Recommendation Report for Planning Permission

REF NO: EP/185/18/PL

LOCATION: Land rear of Beechlands Cottages
Beechlands Close
East Preston
BN16 1JT

PROPOSAL: Demolition of existing buildings & erection of 3 No. dwellings with associated parking, alterations to existing access & relocation of staircase to flats (resubmission following EP/7/18/PL).

DRAWING TITLE
Proposed Floor Plans and Elevations

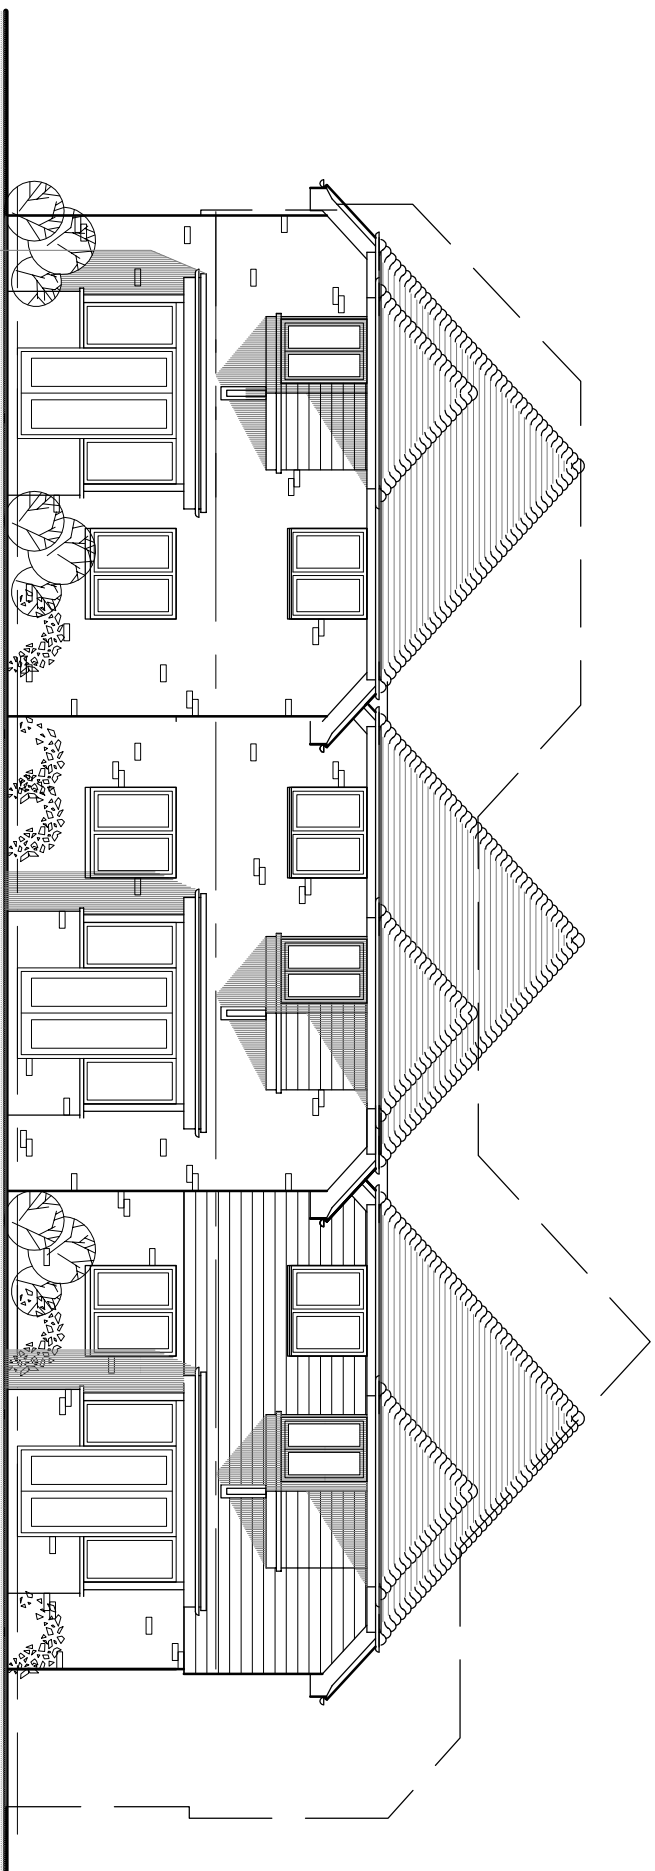
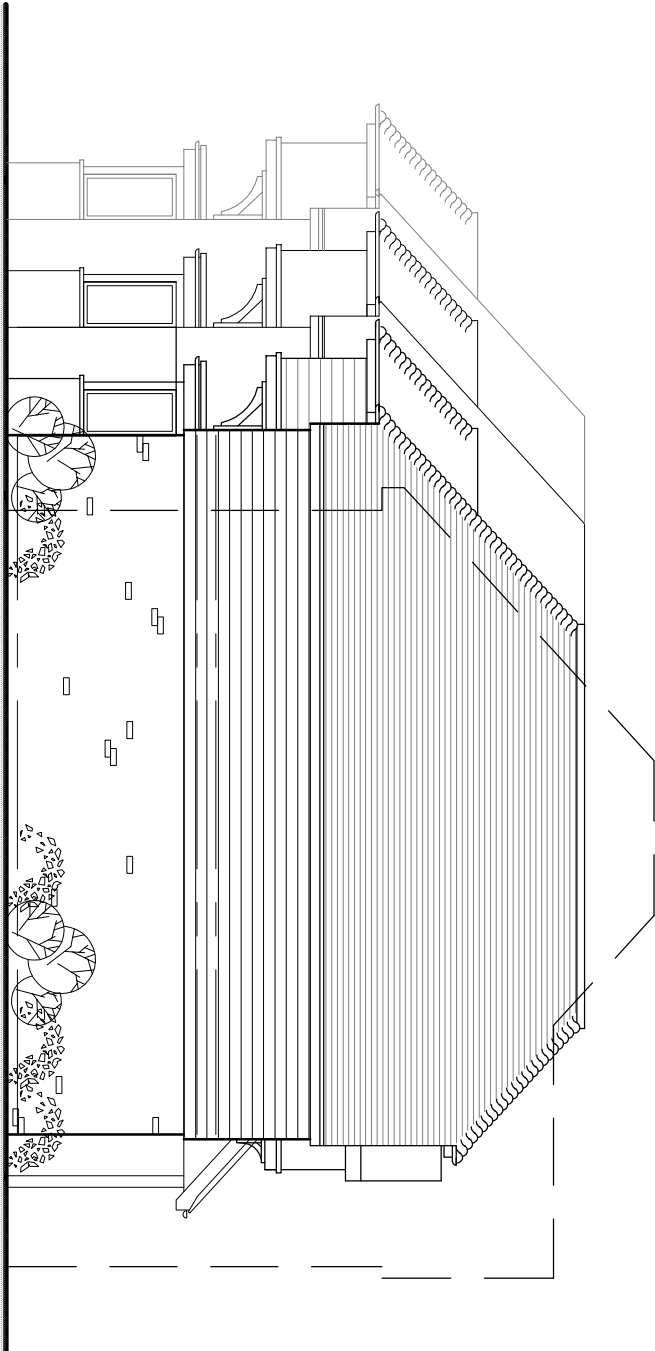
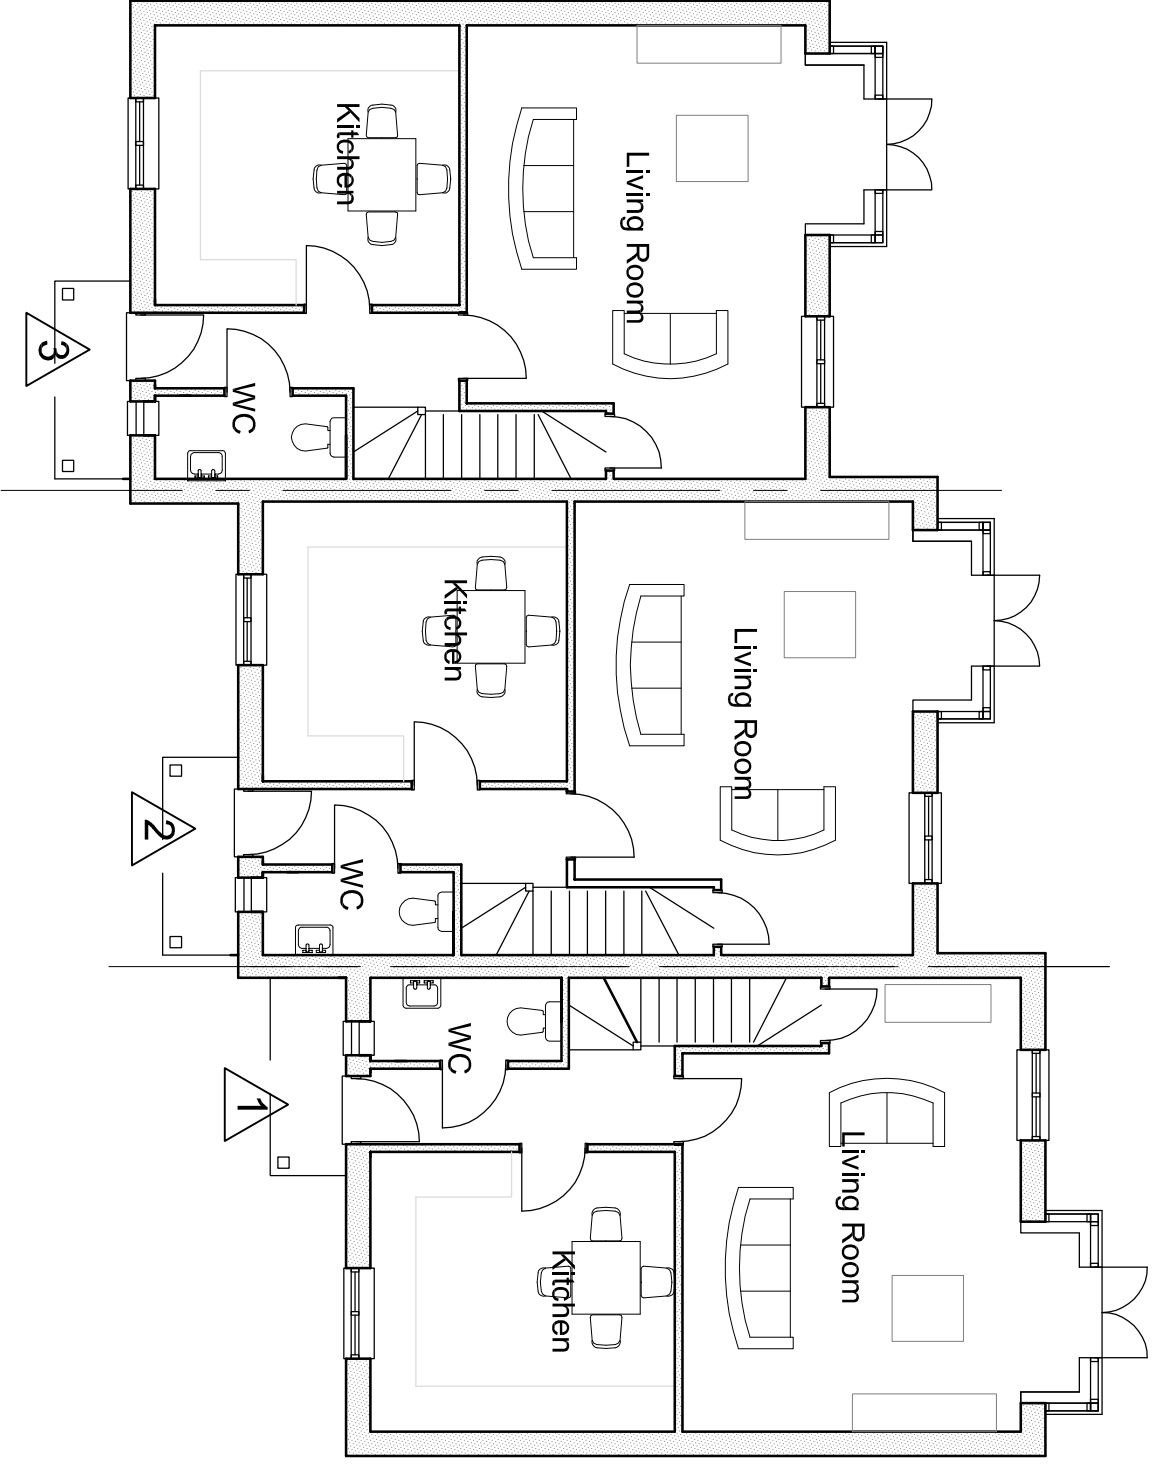
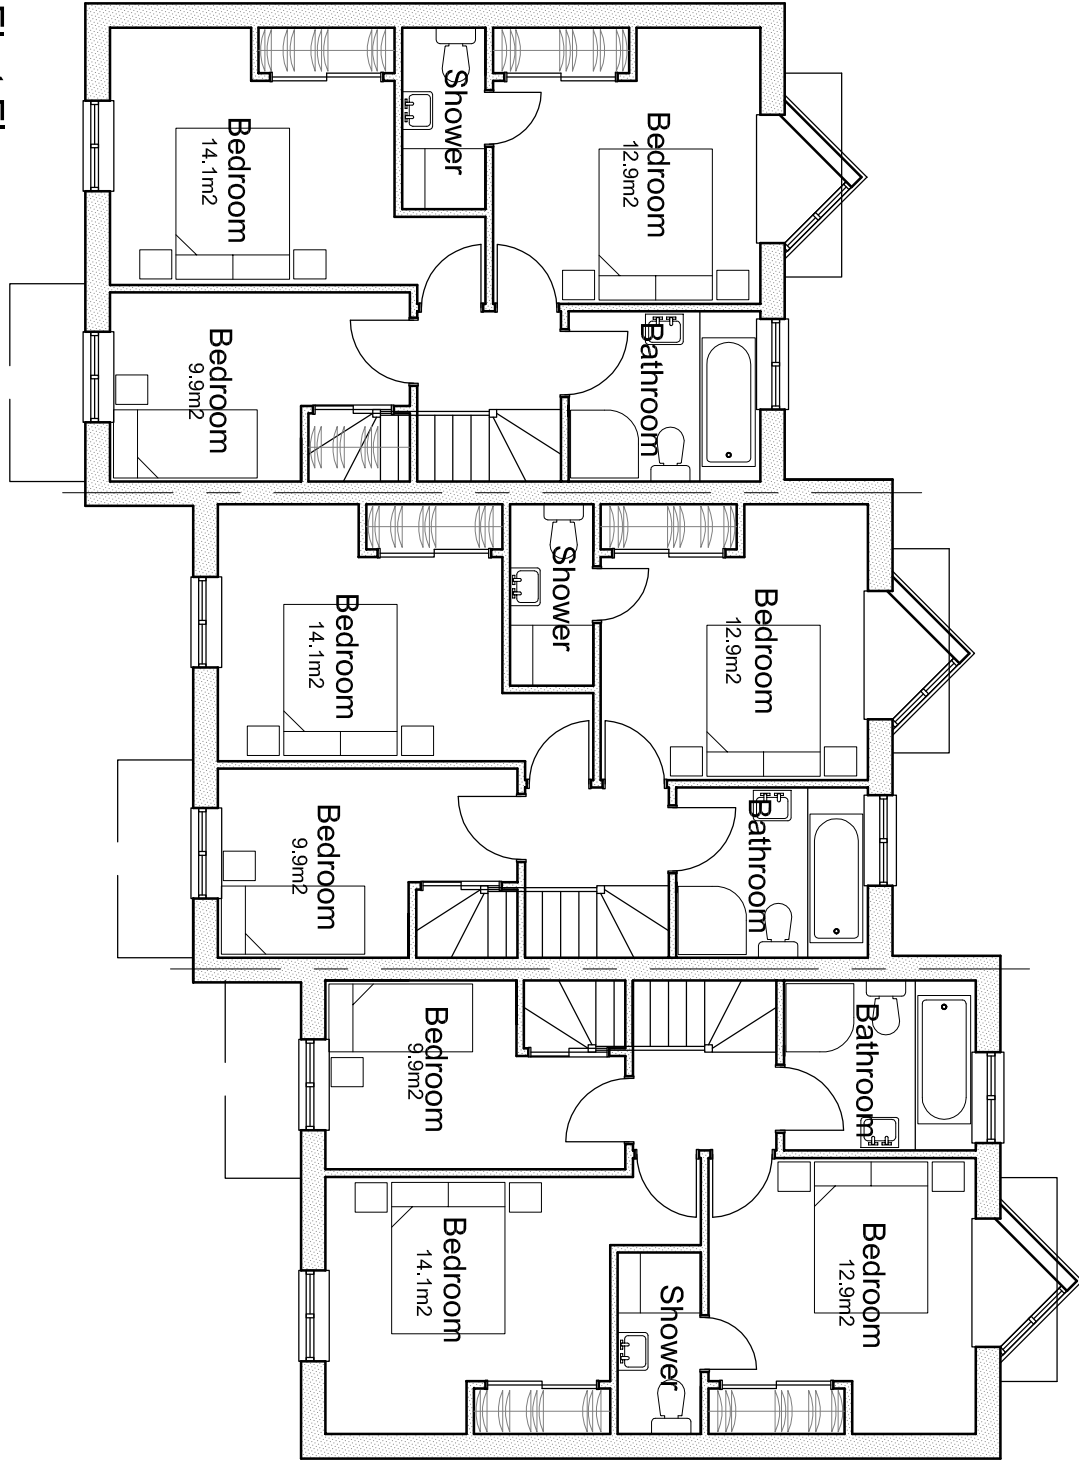
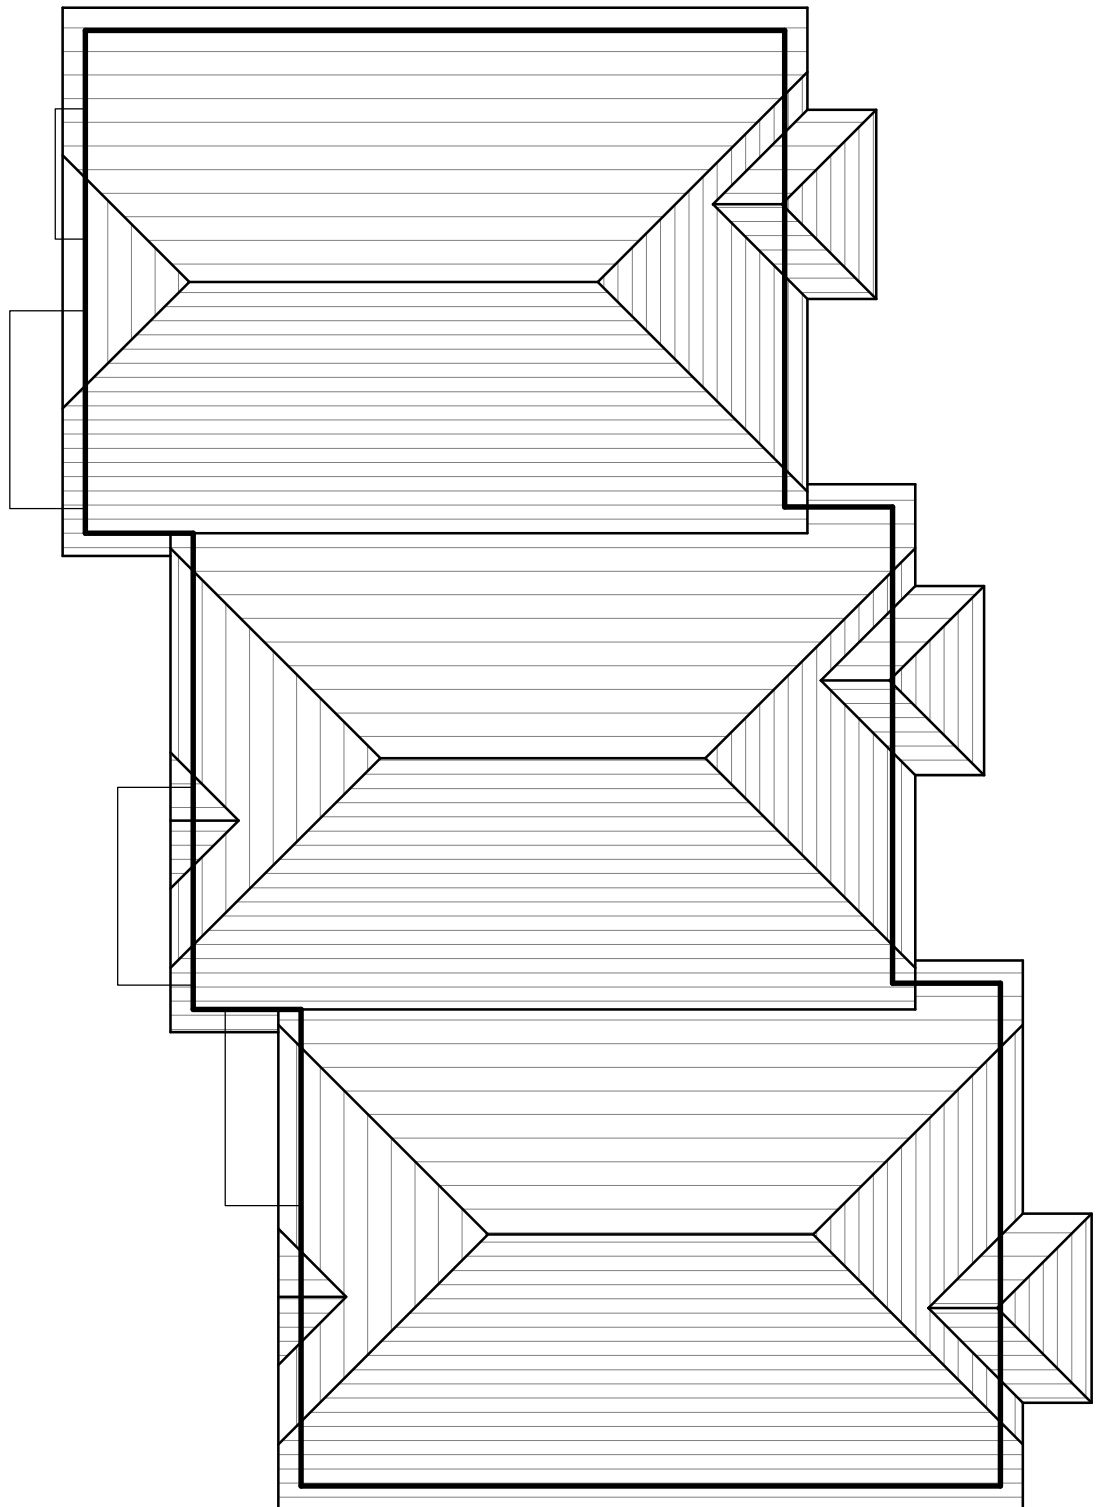
It is noted that the western elevation of the terrace will be located within close proximity of the residential flats behind and above the parade of shops to the west. The height of the terrace has been stepped down to the west and with the exception of the side elevation of the protruding bay at first floor there would be no windows contained within the west facing elevations on the terrace. The glazing in this elevation could be conditioned to be obscured and additional windows could be prevented by condition. These measures are adequate to prevent any concerns from unacceptable overbearing, overlooking or overshadowing impacts on the first floor properties above the shops. The distance is comparable with that which exist to the terrace to the south and the rear of the shops. The distances between the proposed dwellings and those fronting Beechlands Close to the south are also considered to be acceptable. A minimum of 10m is provided between the front elevations of the proposed dwellings and the rear boundaries of these properties.

However the rear elevation of the western most dwelling would be 9m from the rear boundary and the eastern dwelling only 6.2 metres from the rear boundary which would result in unacceptable overbearing and overlooking of the garden of 125 North Lane. The oriel windows proposed would not adequately address the adverse impact of the resultant overlooking. They would still afford overlooking of the rear garden area and it would not be reasonable to impose a condition requiring obscure glazing to the whole of the window since this is the only window serving each bedroom.

Policy DDM1 of the Arun Local Plan further indicates that development will be permitted provided that amongst other considerations the proposal creates attractive places and spaces with the needs of people in mind. On this basis, well designed and adequate amenity space provision for residents is considered essential to meet the policy requirements of the local plan and Central Government Advice. Given the limited garden depths this proposal is considered to adversely impact on the residential amenities of future occupiers and the neighbouring dwelling to the north. The westerly dwelling would also have a poor outlook facing and virtually abutting onto an access road, parking area and shop service area.

DRAWING TITLE		
Partial elevations of existing building showing proposed new stairs

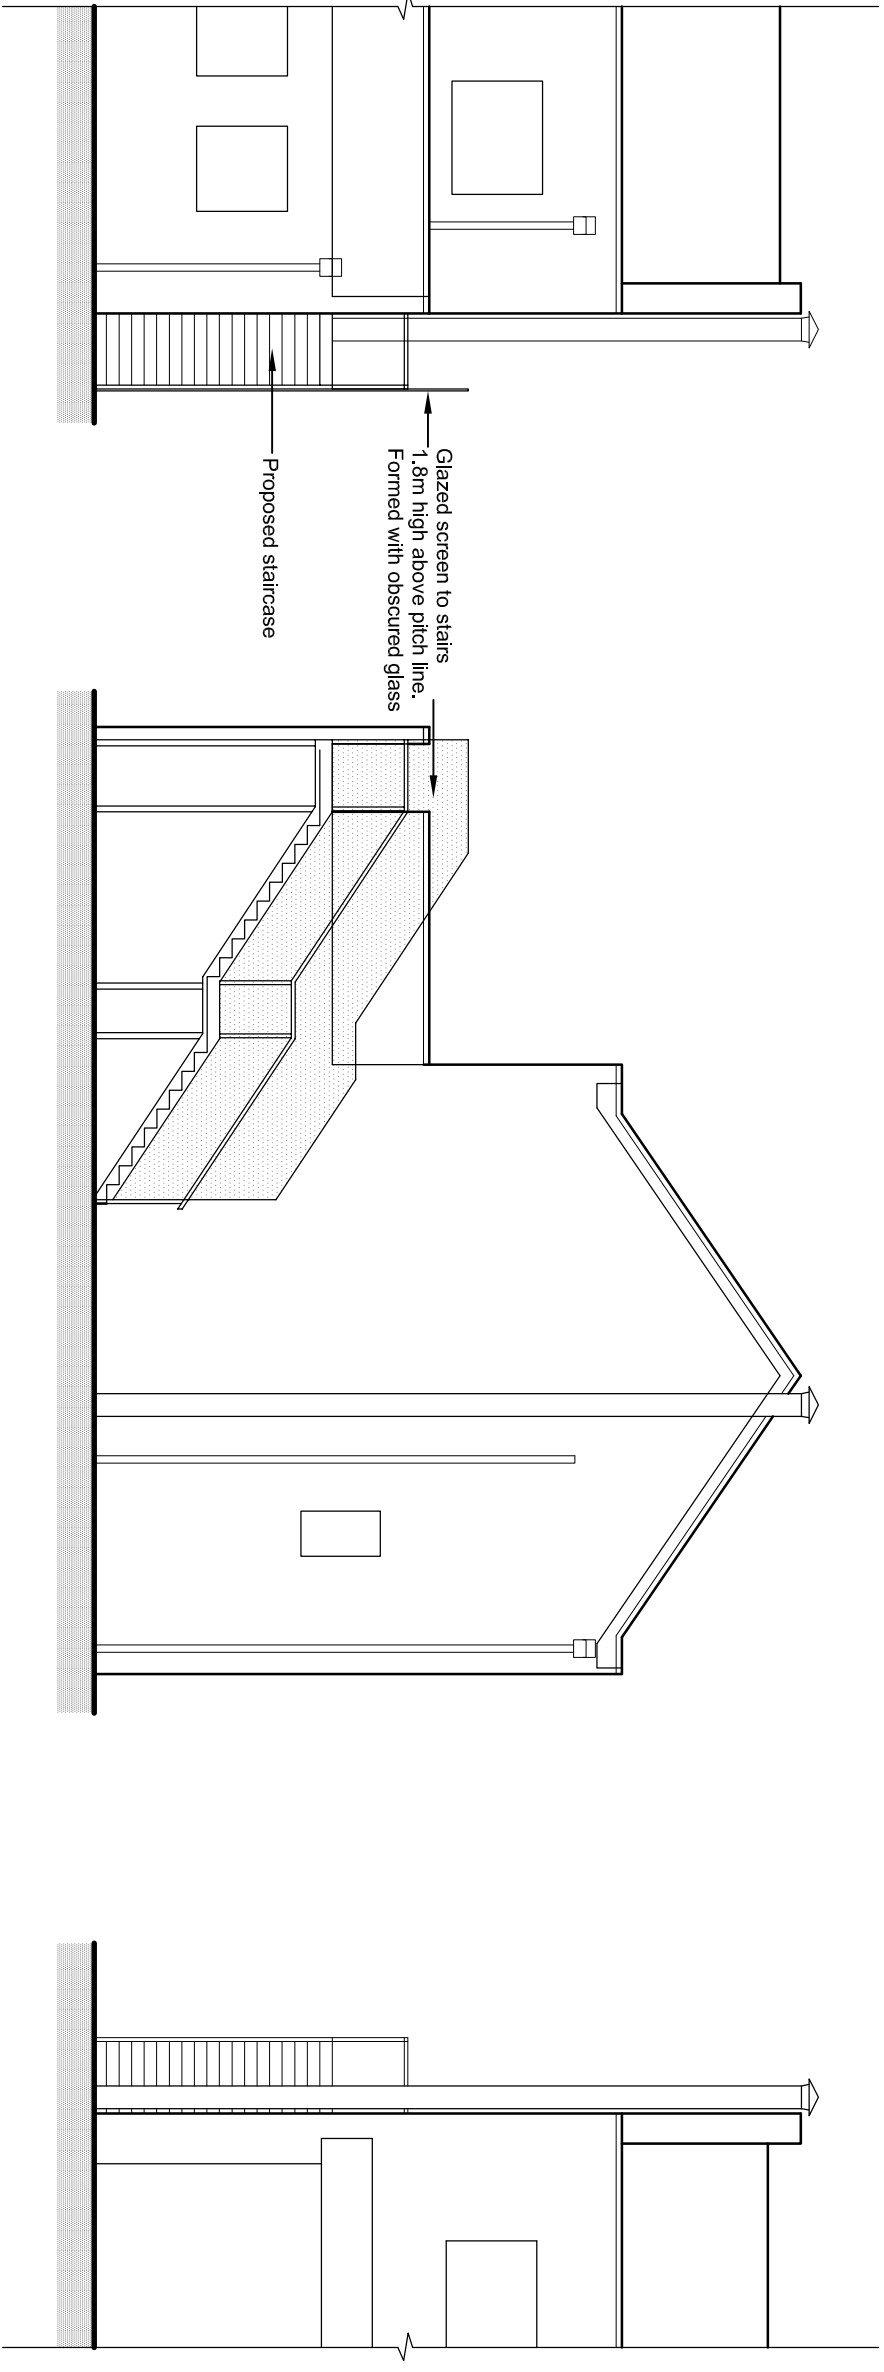
The proposal includes relocation of the existing fire escape staircase from the rear of the shops to the northern end of the parade which was approved under EP/7/18/PL. This would increase the potential for overlooking in this area and potentially increase activity adjacent to the boundary. The relocated staircase, as previously mentioned, is for emergency use only and despite resulting in no additional overlooking than the existing balcony, is indicated on the north elevation plan to be screened with 1.8m high obscured glass. Therefore whilst the staircase would be located adjacent to the northern boundary it would not result in direct overlooking of the neighbouring dwelling.
